August 30, 2013

Subject: Approval, Cliff Island Septic System Association, Cliff Island, Cumberland

The Division of Environmental Health has completed a review of a design for an engineered subsurface sewage disposal system design, to serve Cliff Island Septic System Association. The HHE-200 Form dated 09/27/12 was prepared by Mark Hampton, S.E. The system was designed by Pinkham & Greer Consulting Engineers, with plans signed and stamped by you. The application was complete for processing on 08/08/13.

DISPOSAL BEDS #1 & #2 PLAN
SCALE: 1"=20'

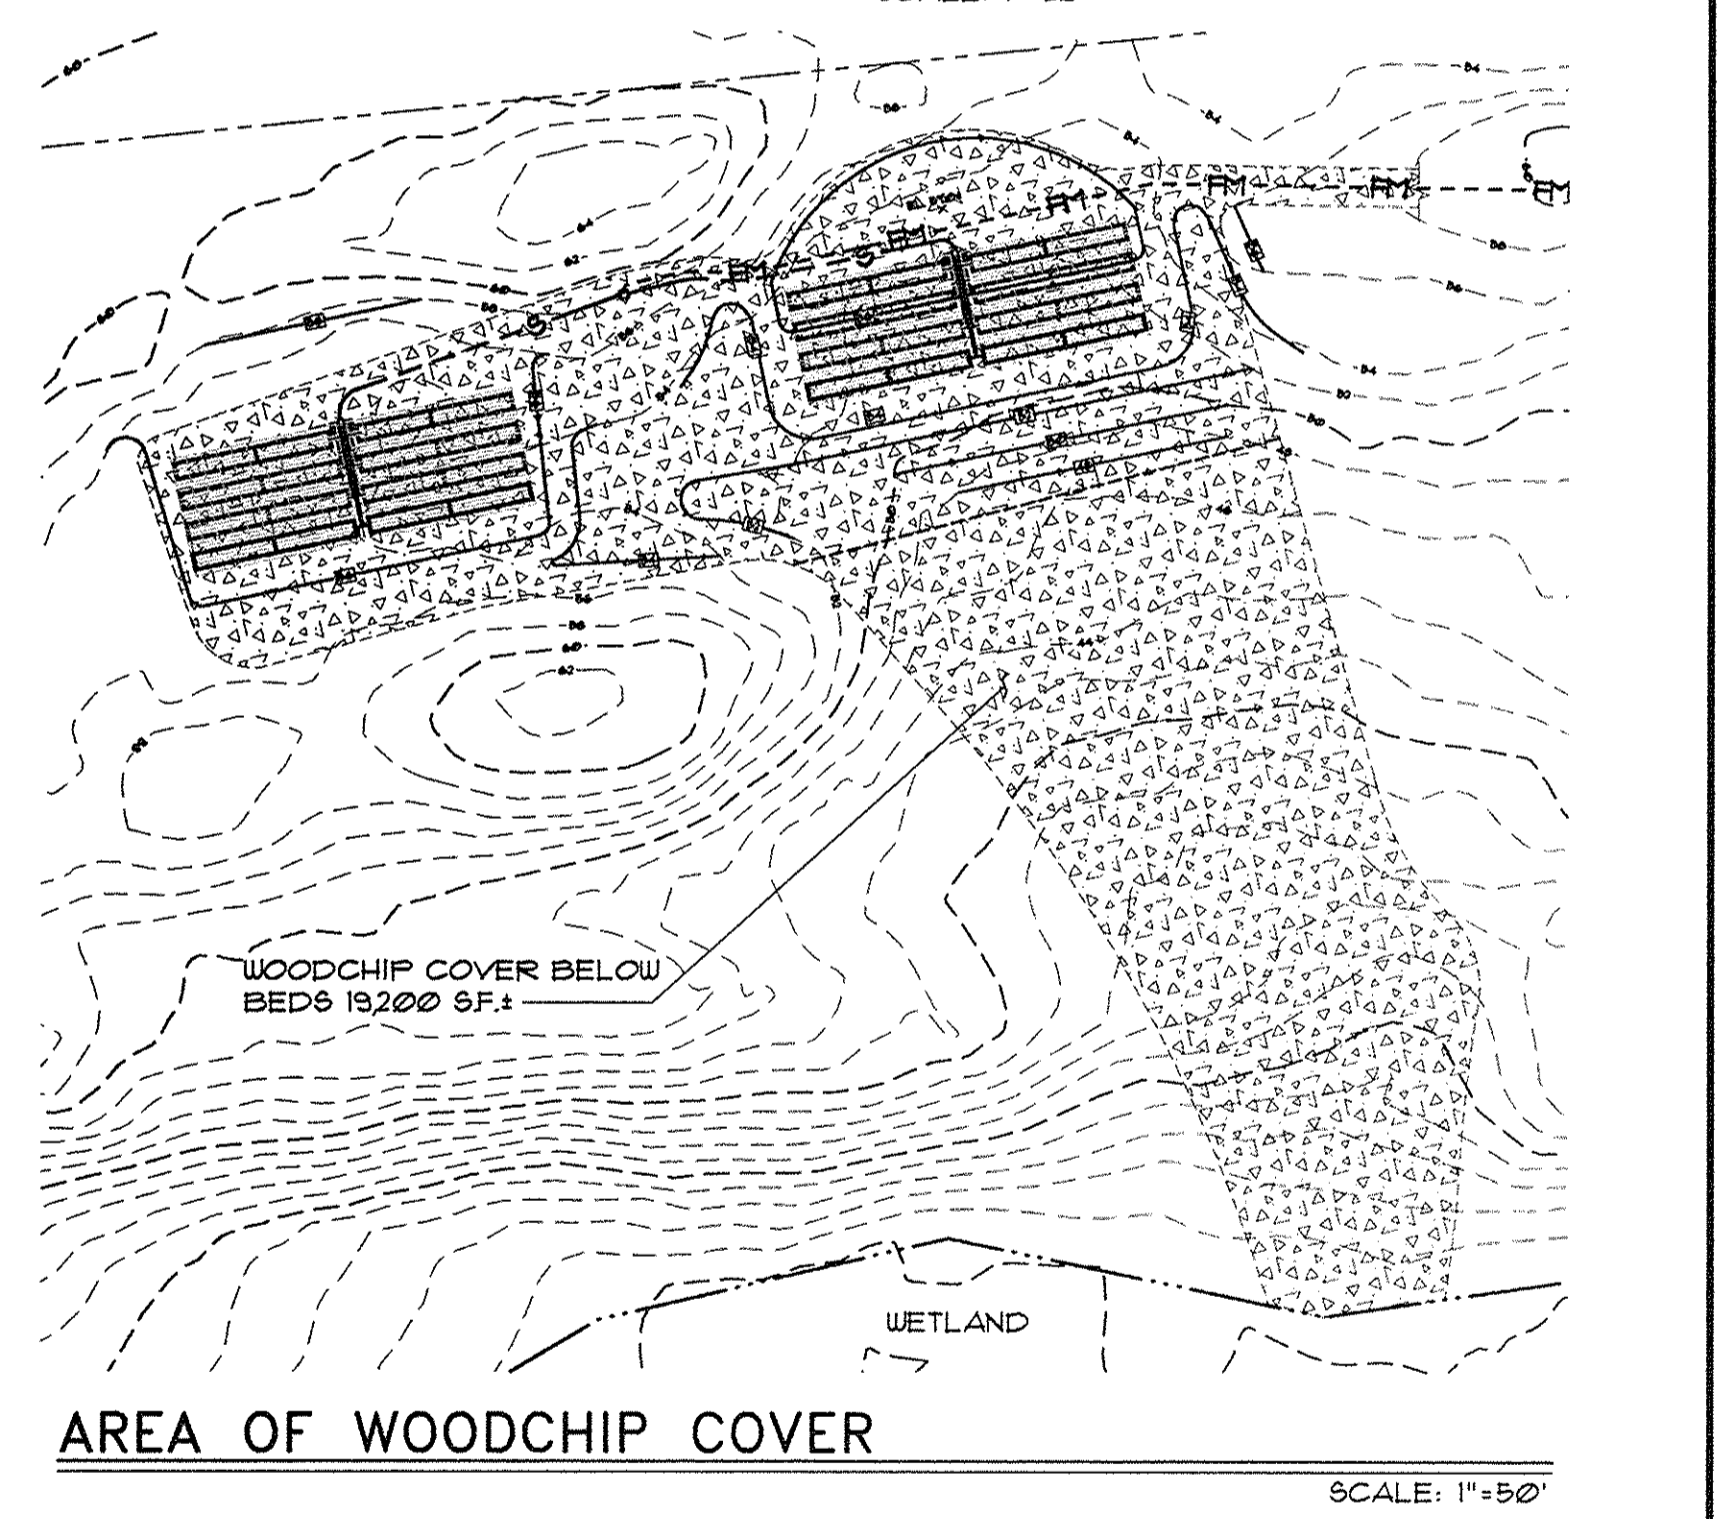
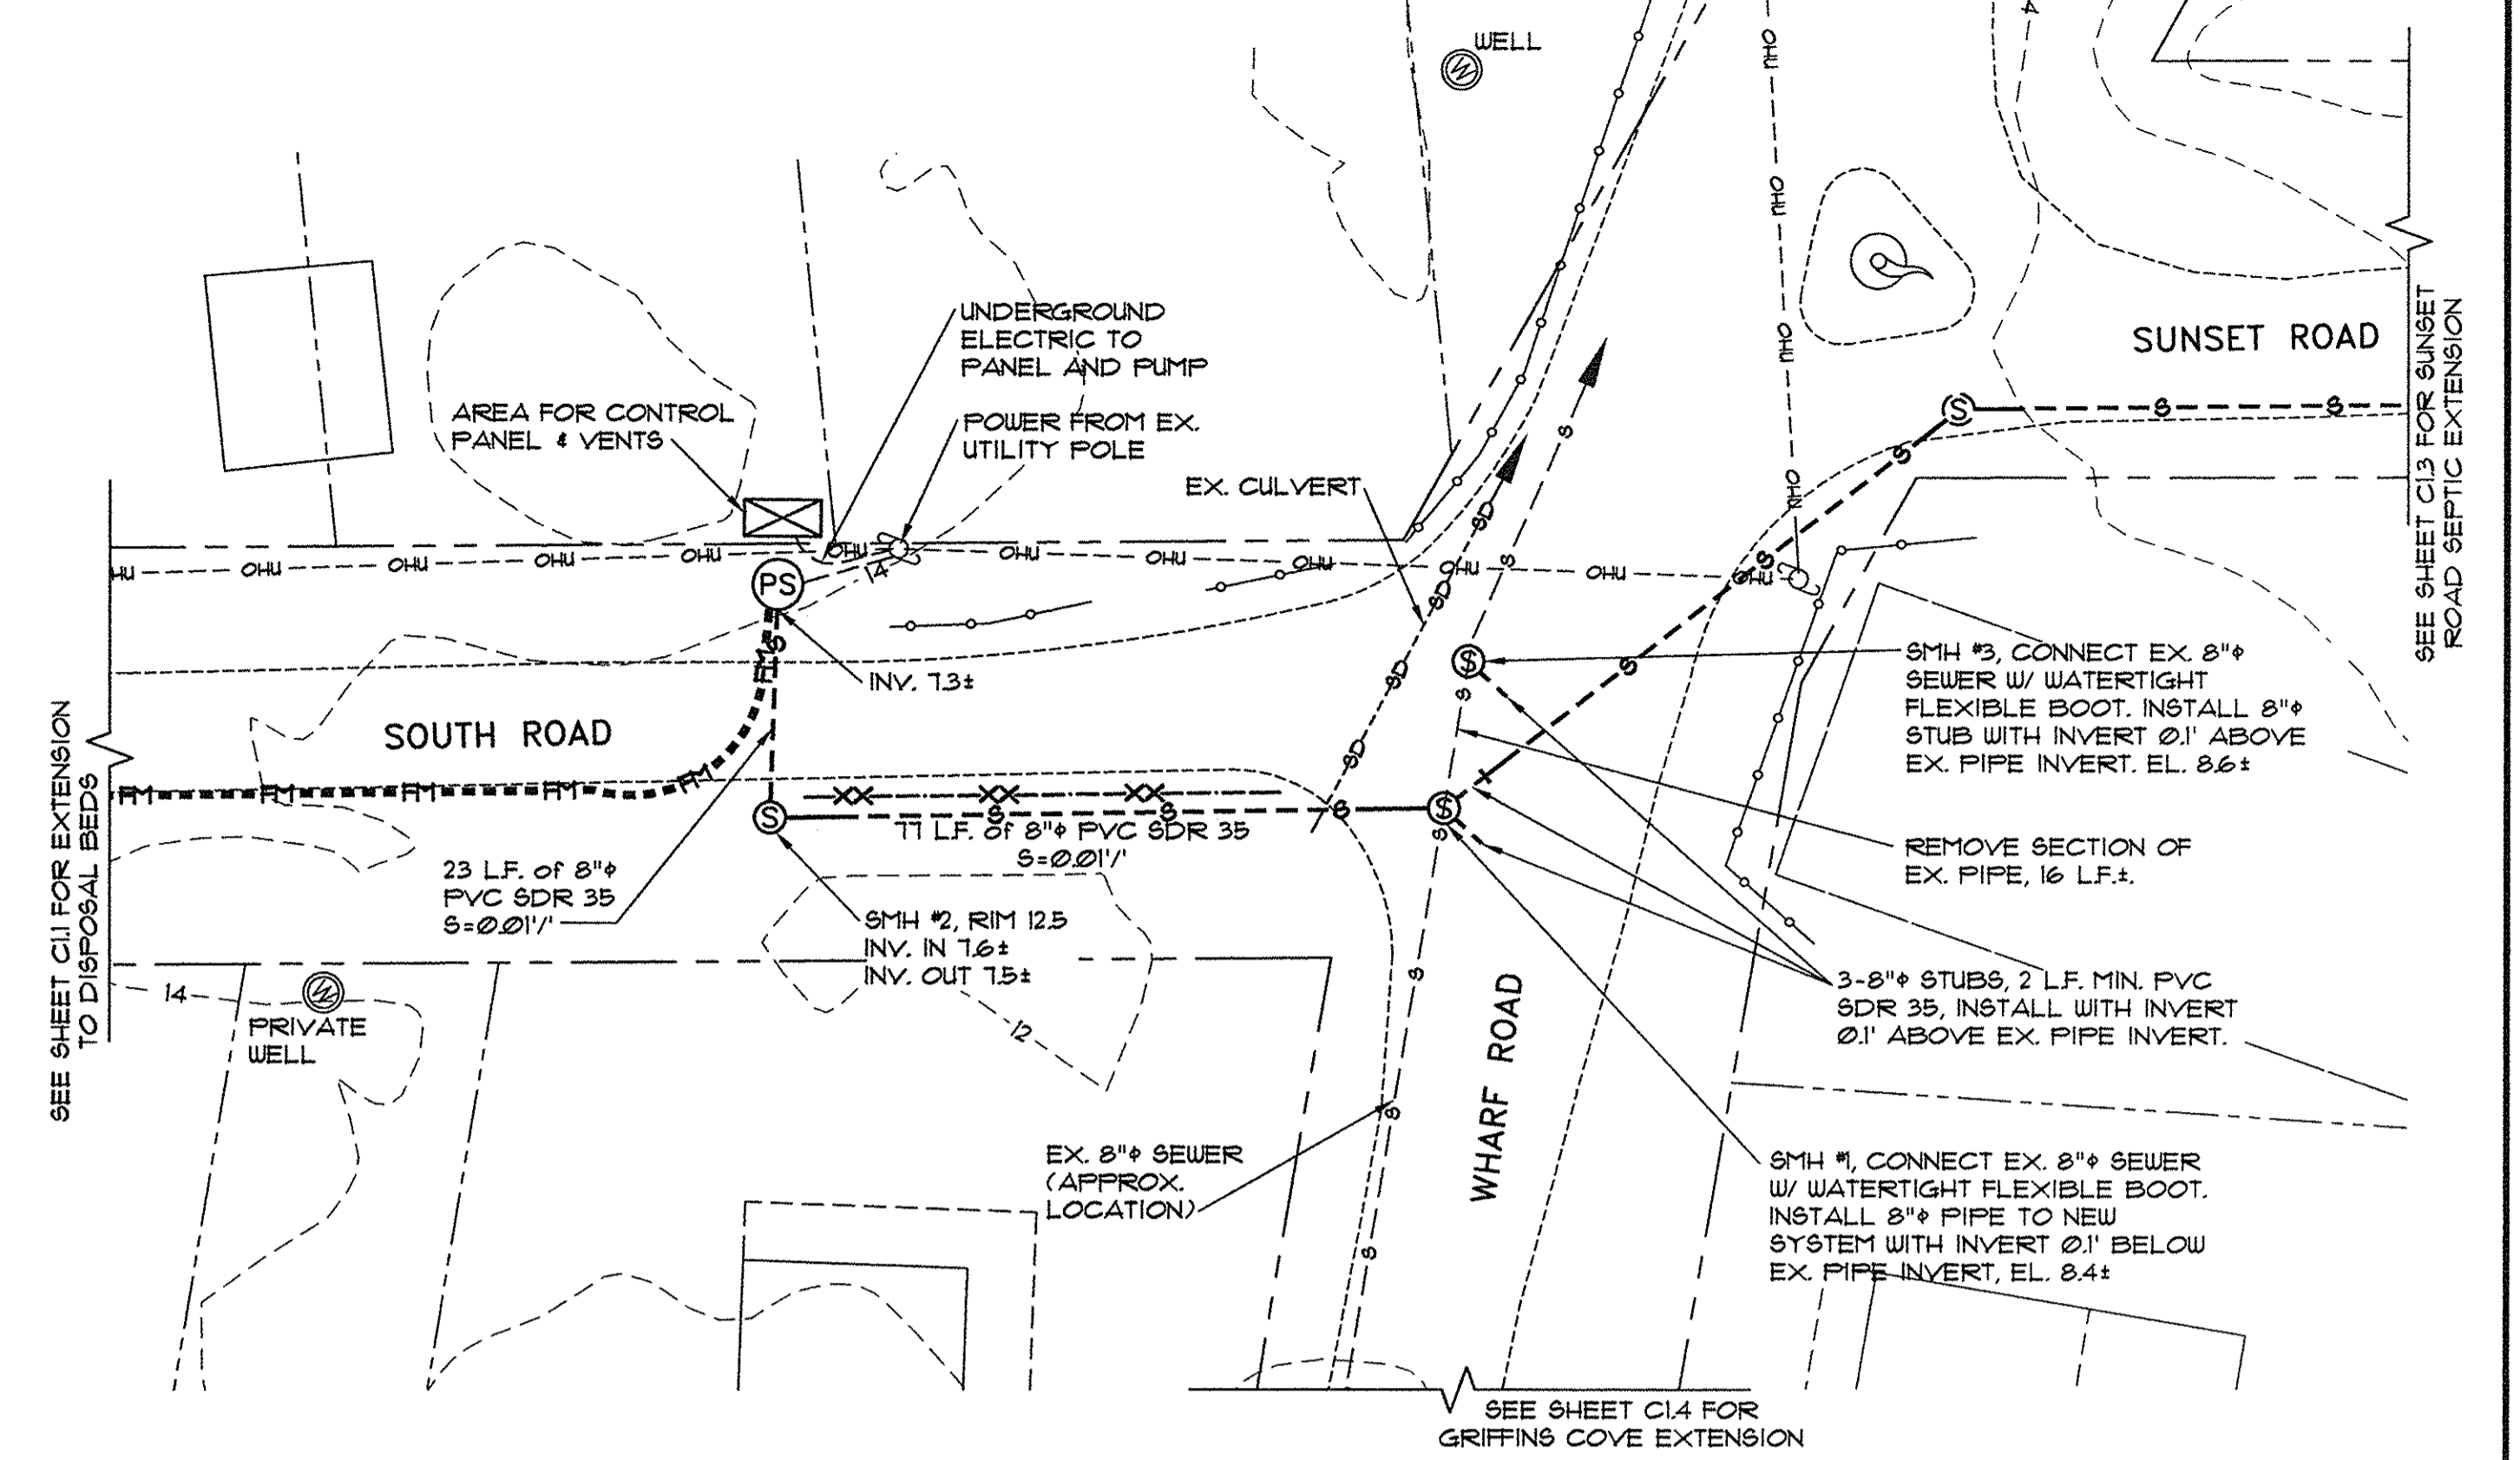
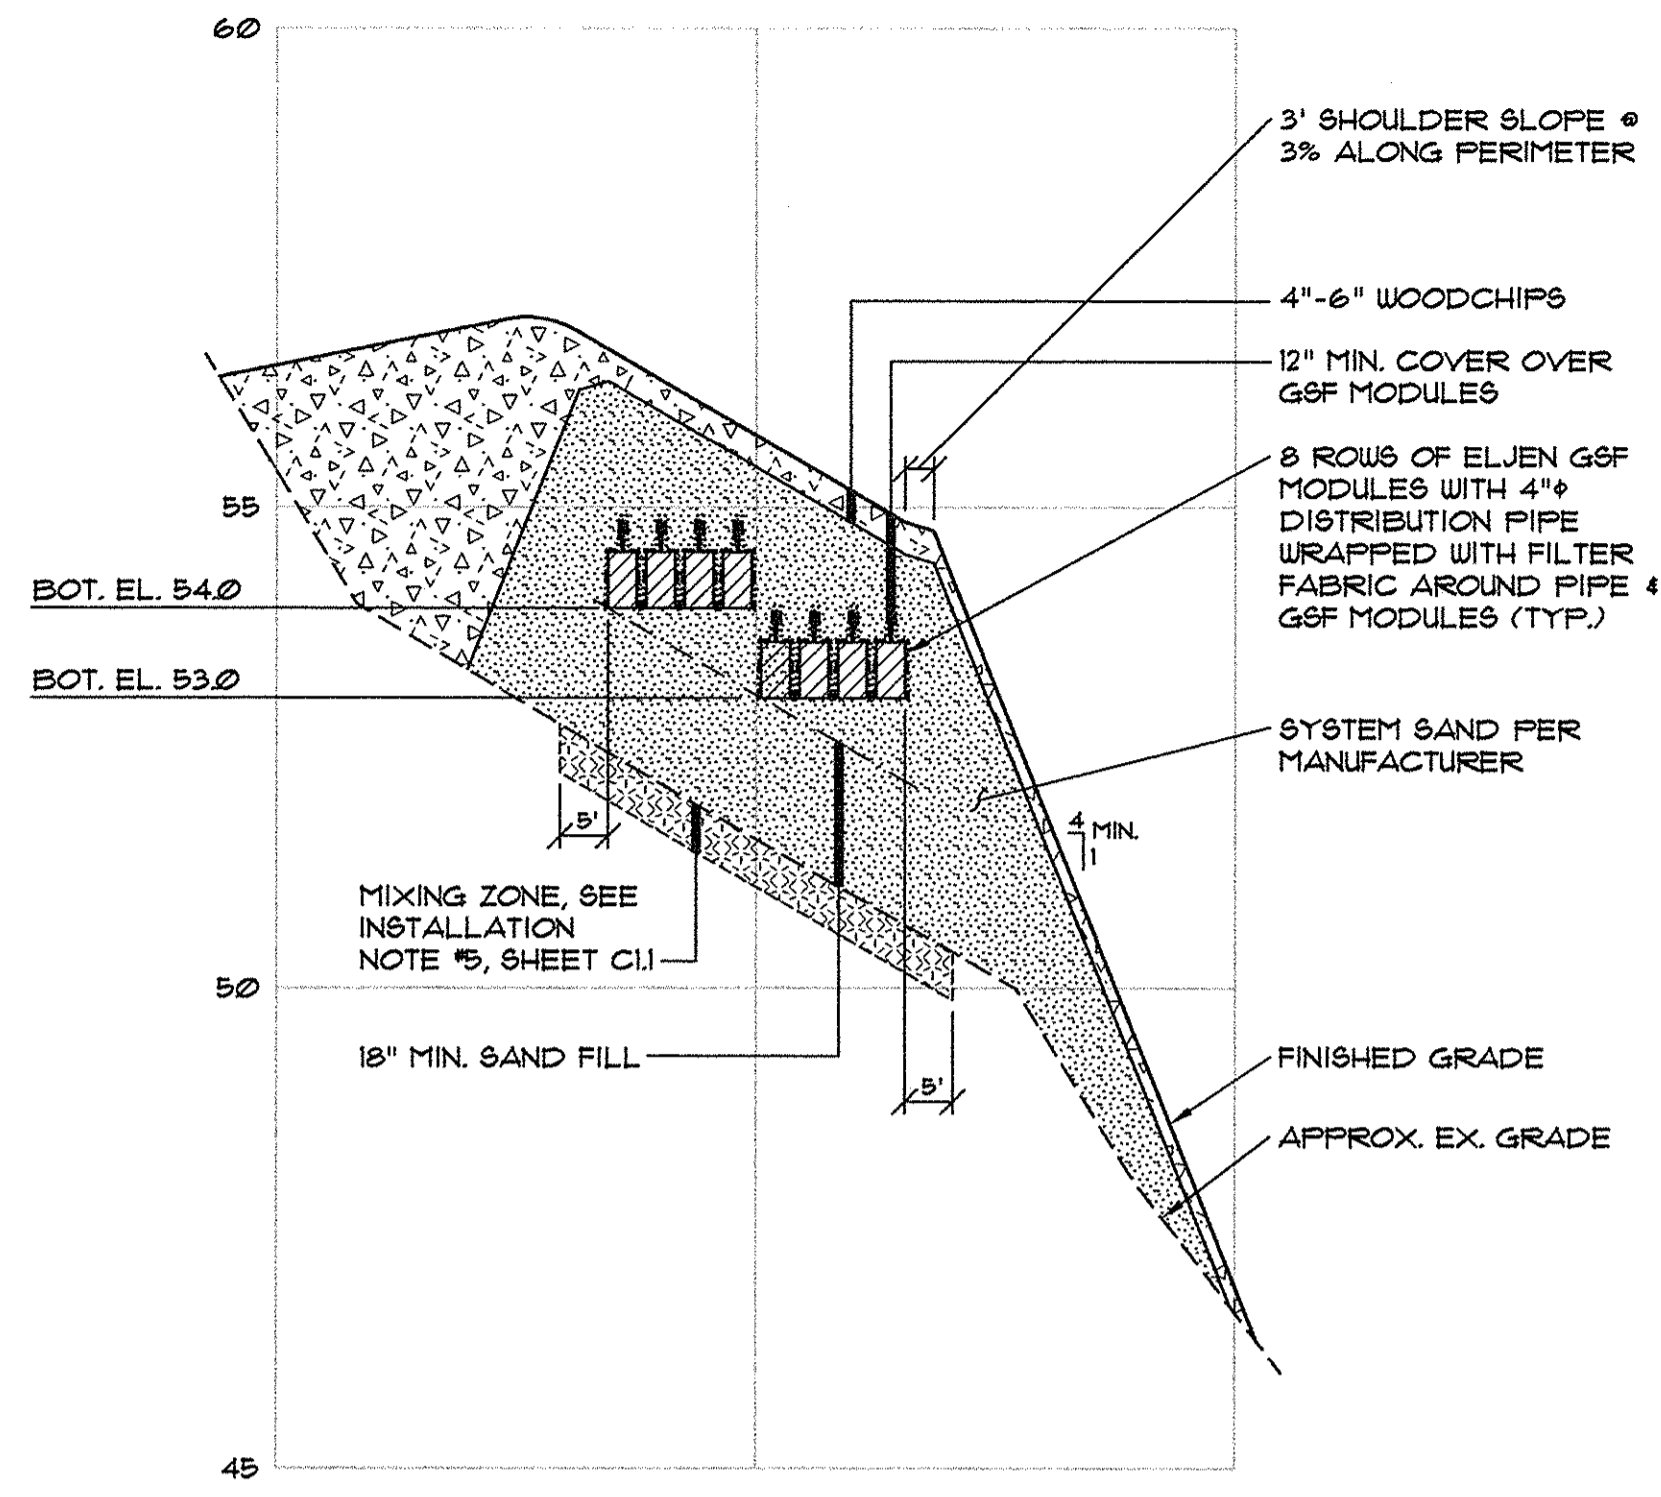
MDEP commented that no bedrock depth/elevation data was found to verify there will be a 2.96-foot bedrock/disposal field bottom separation distance as recommended by the mounding analysis. Soil data from two test pits was provided, but locations of the pits are not identified in the plans - additional observation holes appear to be warranted at the uphill edge of the proposed disposal fields to determine bedrock depth/elevation. Due to results of the transmissivity analysis, it is critical to insure this separation distance is maintained to minimize potential of a down gradient effluent breakout.

1. Prior to issuance of a permit to install the system, the design engineer must amend the site plan(s) to show that test pits are located within the disposal areas, and amend the O&M Manual to include periodic inspection and maintenance of the woodchip cover. Copies of these amended documents must be provided to the LPI and
